Ref: Application AW/272/19/HH

My husband and I live at 49, Westminster Drive and have just seen the planning application for no 51 Westminster Drive, the middle of our block of three houses. It transpires that a previous owner of no 51 has slatted over the foul water inspection cover serving our property. This cover is just over the boundary line of our property and on to his. (no 51)

No.	Revisions:	Date:
-----	------------	-------

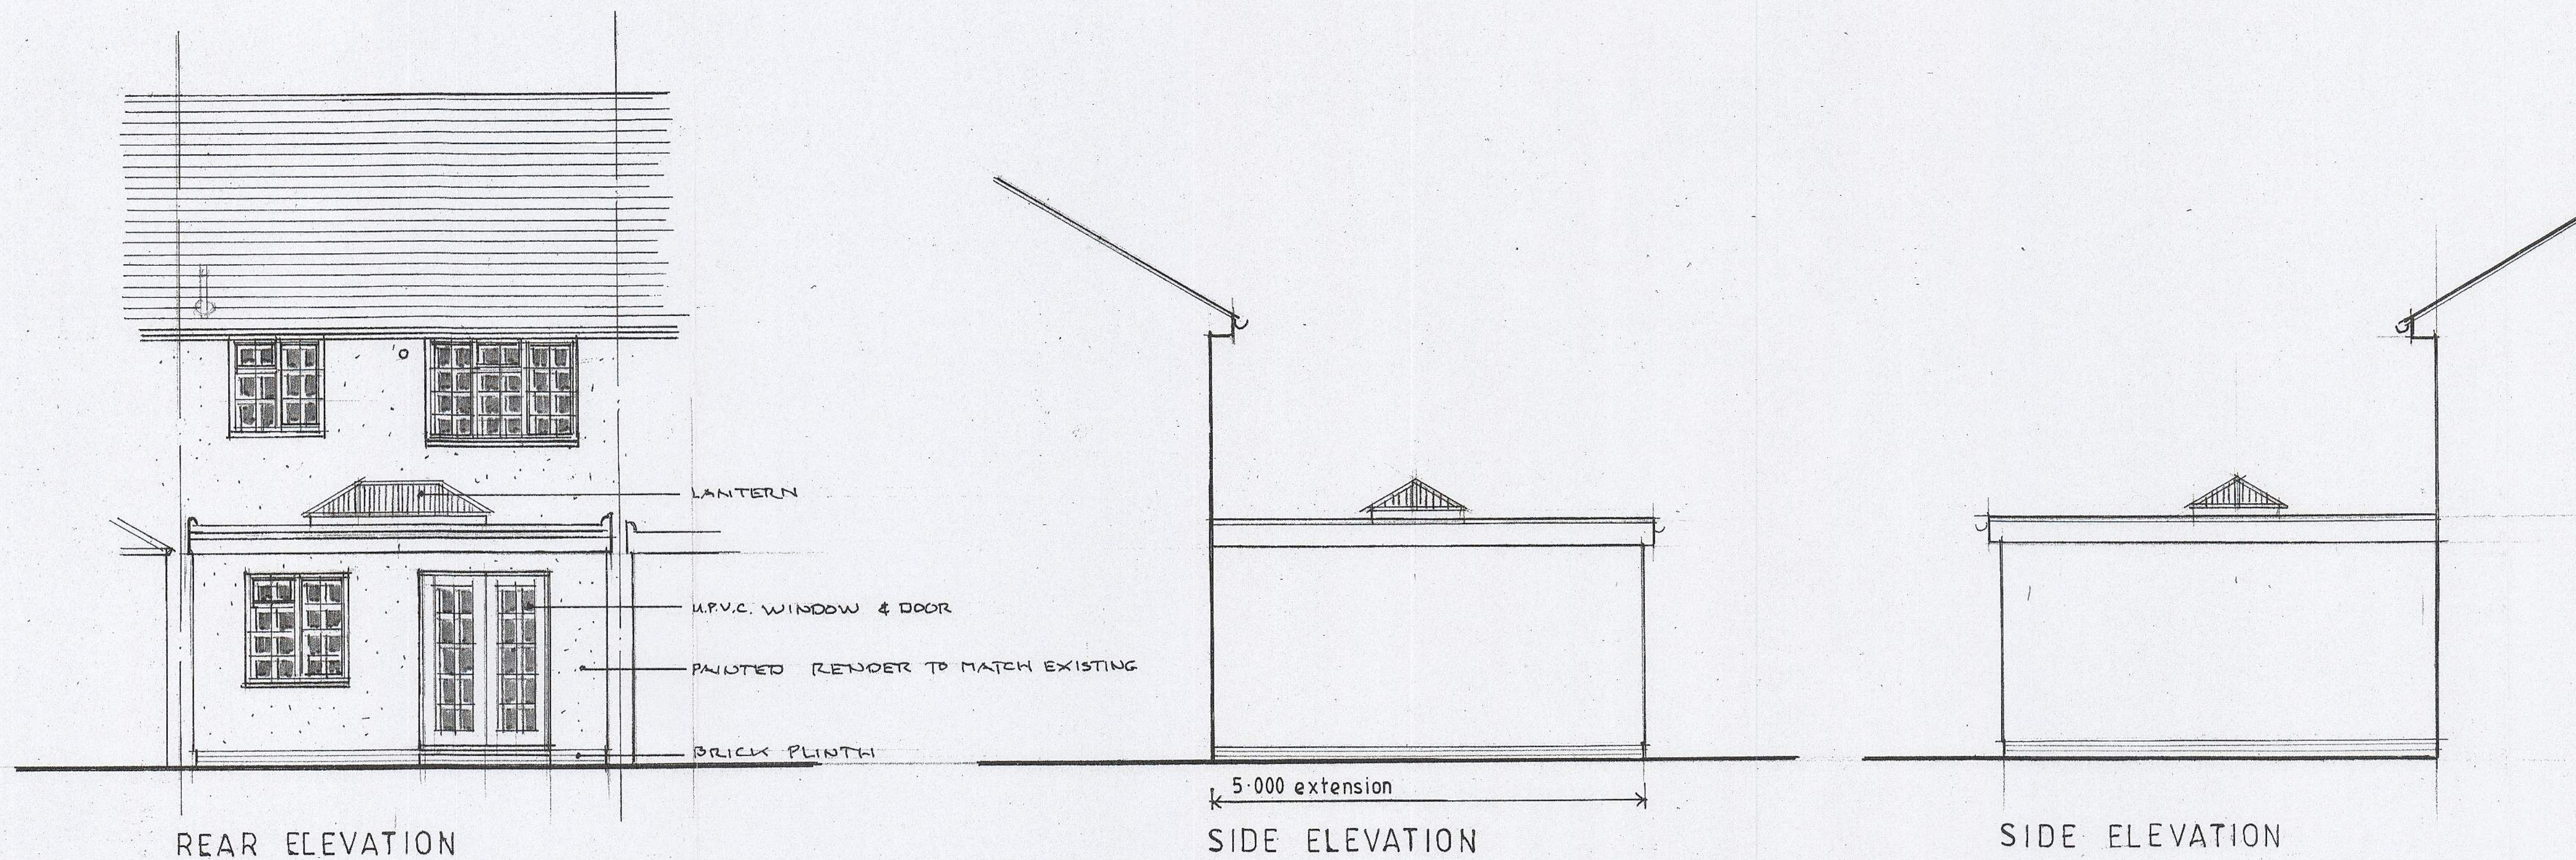
There is a foul water drain for all three adjoined properties which runs along under the ground about two and a half metres out from the back walls of no 51 and 53. We are also concerned that the foul water insp cover on no 53's ground has been covered over as well as there is an extension on the back of this house.

We are worried therefore that the architect and builders will not be aware of this foul water drain run (with relevant inspection covers) which runs close to the back of no's 51 + 53, as there is no visual evidence of this. We have lived here for over 40 years and know exactly where the inspection covers were situated before home improvements took place.

We have spoken to a retired building inspector and current architect and he informed us that because the drain run serves two or more properties Southern Water are responsible for it and will insist there is inspection access matching their records and will need to see plans of the proposed development in order to give consent to works above a drainage run. We understand that Southern Water have the power to refuse building works permission and that special measures need to be in place to protect the drain from damage or collapse.

Whilst we have no objections to the extension being built we would like all necessary precautions to be taken and the foul water inspection cover to be re-instated in an accessible place.
